Ribble Valley Borough Council
Council Offices
Church Walk,
Clitheroe
Lancashire
BB7 2RA

Phone: 0300 123 6780
Email: developeras@lancashire.gov.uk
Your ref: 3/2025/0564
3/2025/0565
Our ref: 3/2025/0564/HDC/KW
3/2025/0565/HDC/KW
Date: 29 January 2026

Location: 45 - 47 Whalley Road, Clitheroe, BB7 1EE
Proposal: Planning permission for proposed change of use from light industrial to residential (use class C3) and commercial (use class E(c)(iii)) involving internal and external alterations.
Grid Ref: 374236 441280

drawing number
PL02

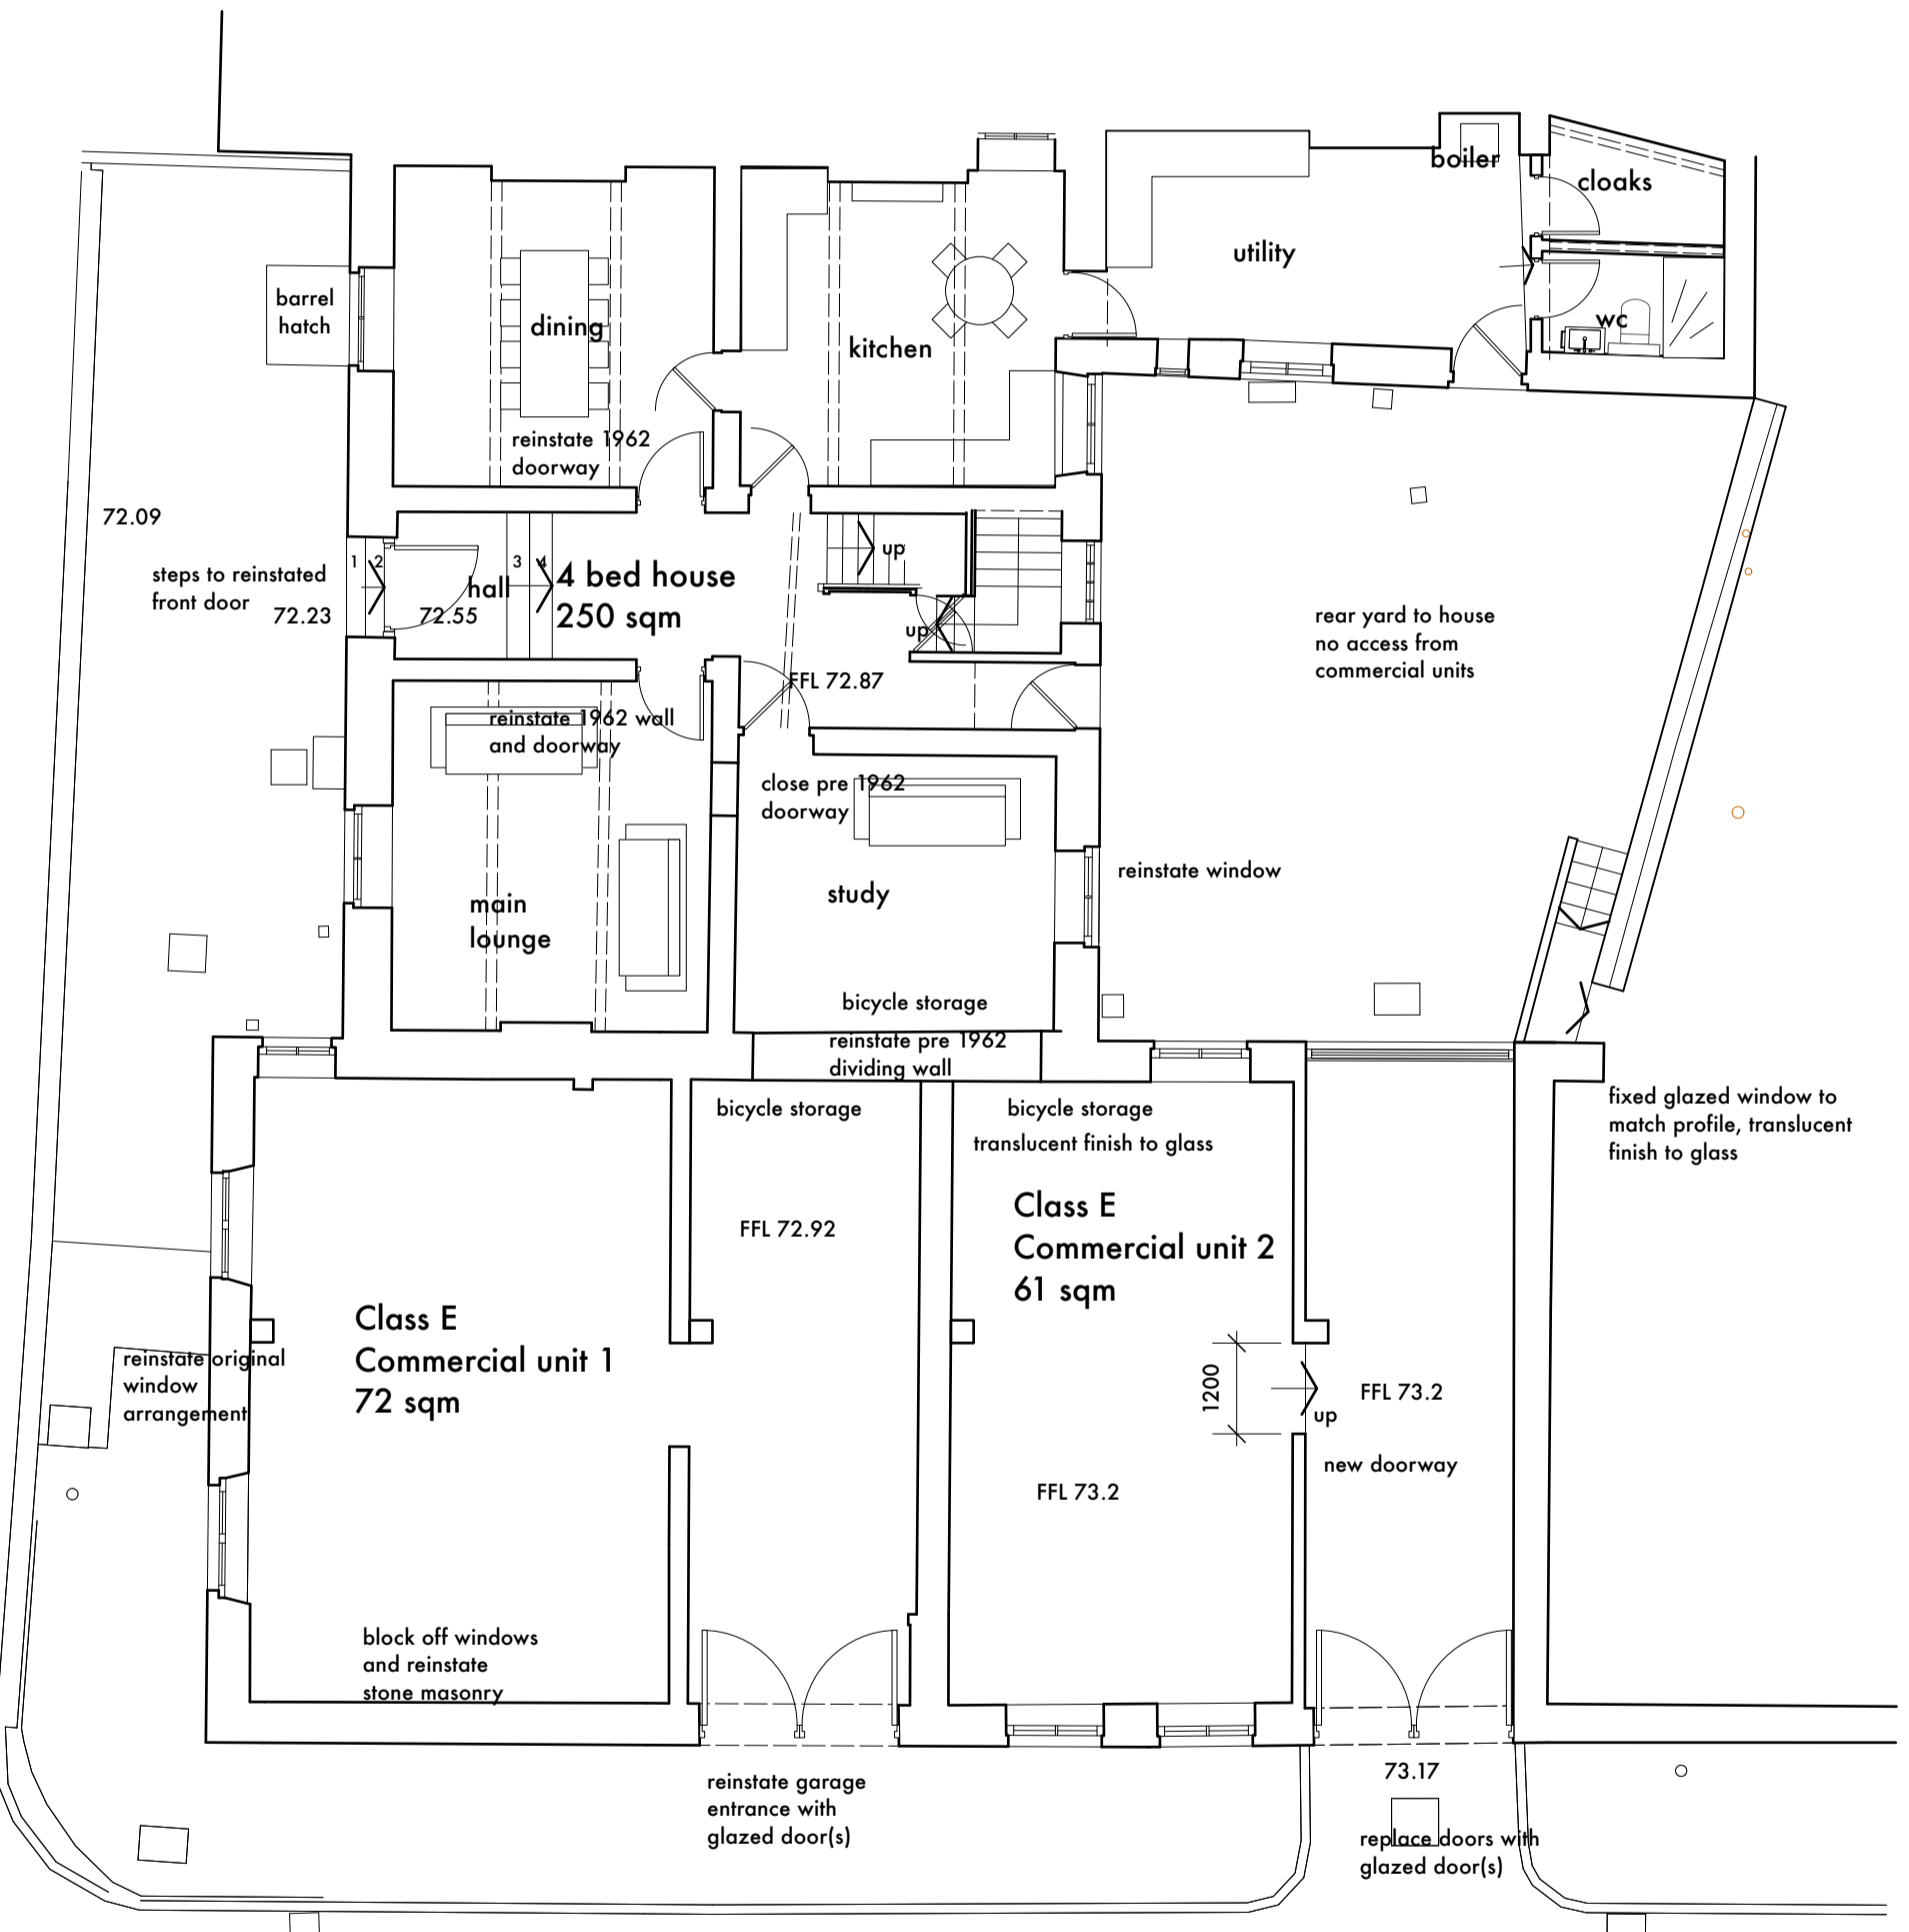
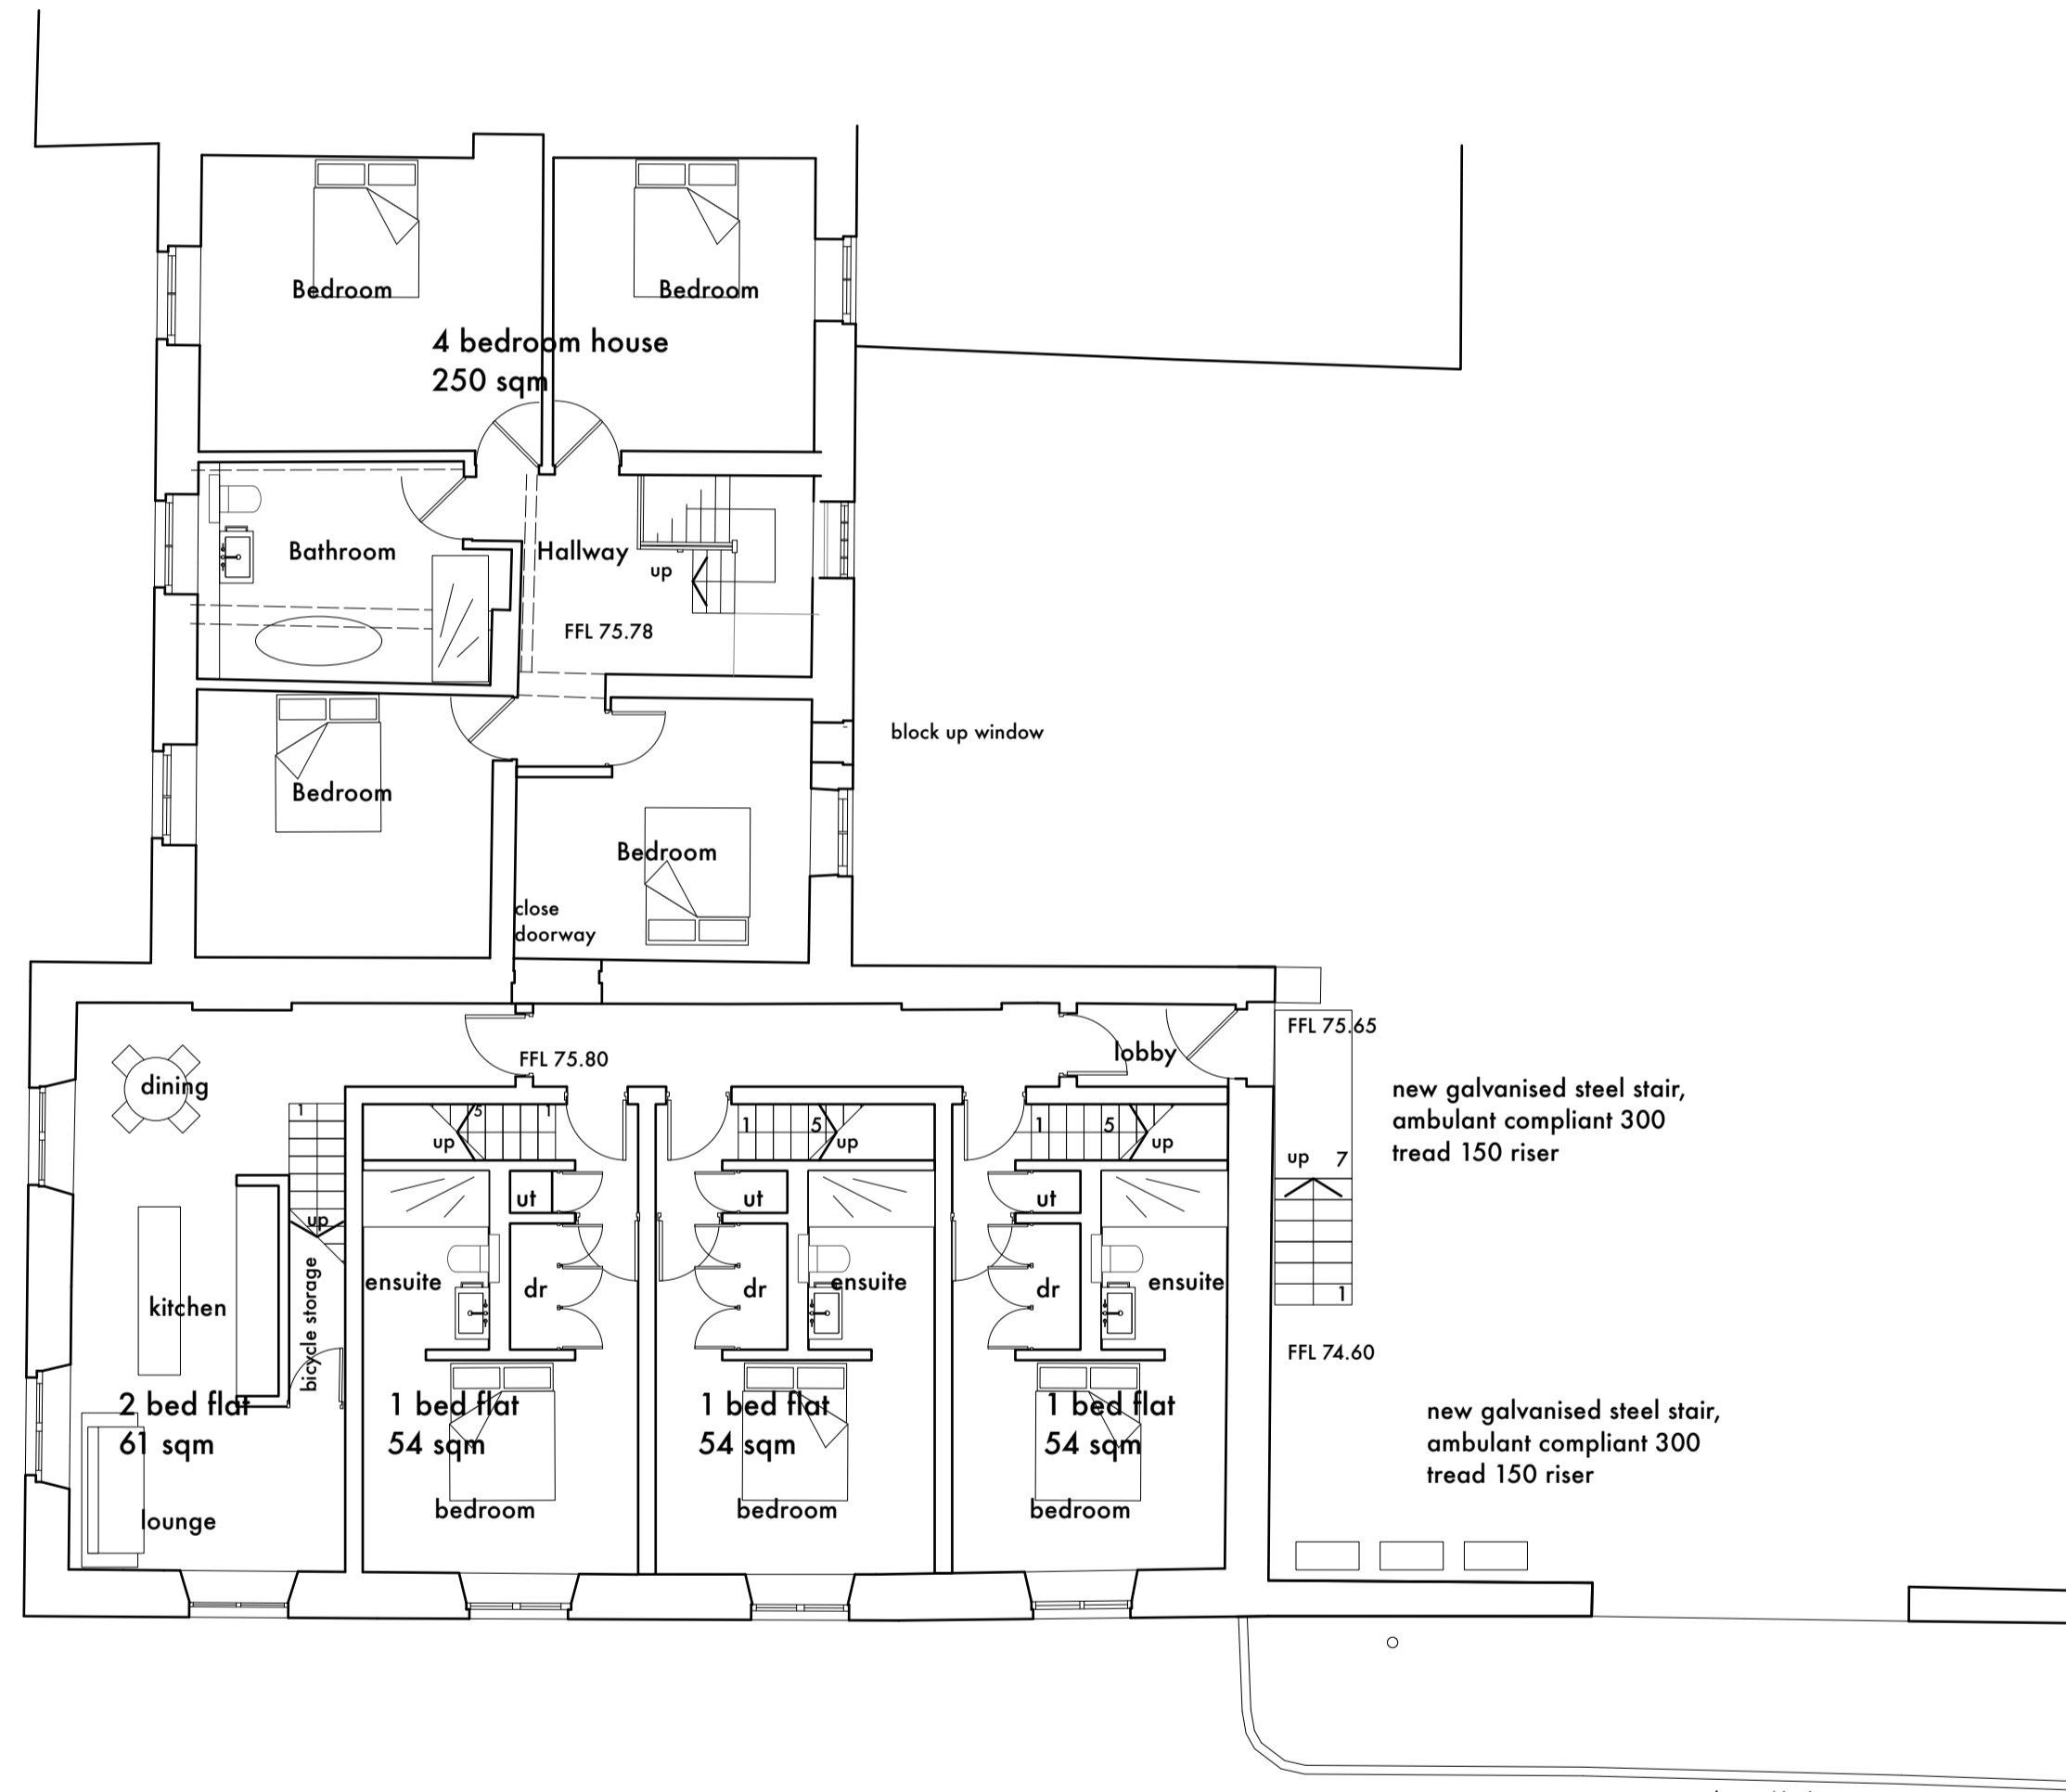
The LHA has reviewed drawing number PL01 Rev D. Currently, six parking spaces are proposed within the parking area, allocated to the residential element of the development.

Two spaces are designated for the four-bedroom dwelling. The LHA would expect three off-street parking spaces for dwellings with four bedrooms or more. Given the sustainability of the area, situated close to amenities and public transport options, the LHA would accept a shortfall of 1 parking space for the 4 bedroom dwelling and will condition that cycle storage is provided within the site to further encourage and promote sustainable transport.

Four parking spaces are allocated for the flats. Drawing number PL02 Rev A indicates that three one-bedroom flats and one two-bedroom flat are proposed. In accordance with the LHA's parking standards (as set out in the Joint Lancashire Structure Plan), one-bedroom flats should be provided with one off-street parking space each, and two-bedroom flats should be provided with two.

Although the LHA have not yet updated their parking standards following the introduction of Class E use, the LHA applies an average of one car parking space per 35 square metres for Class E uses. Based on the internal floor layout, Unit 1 would require two parking spaces, and Unit 2 would require one.
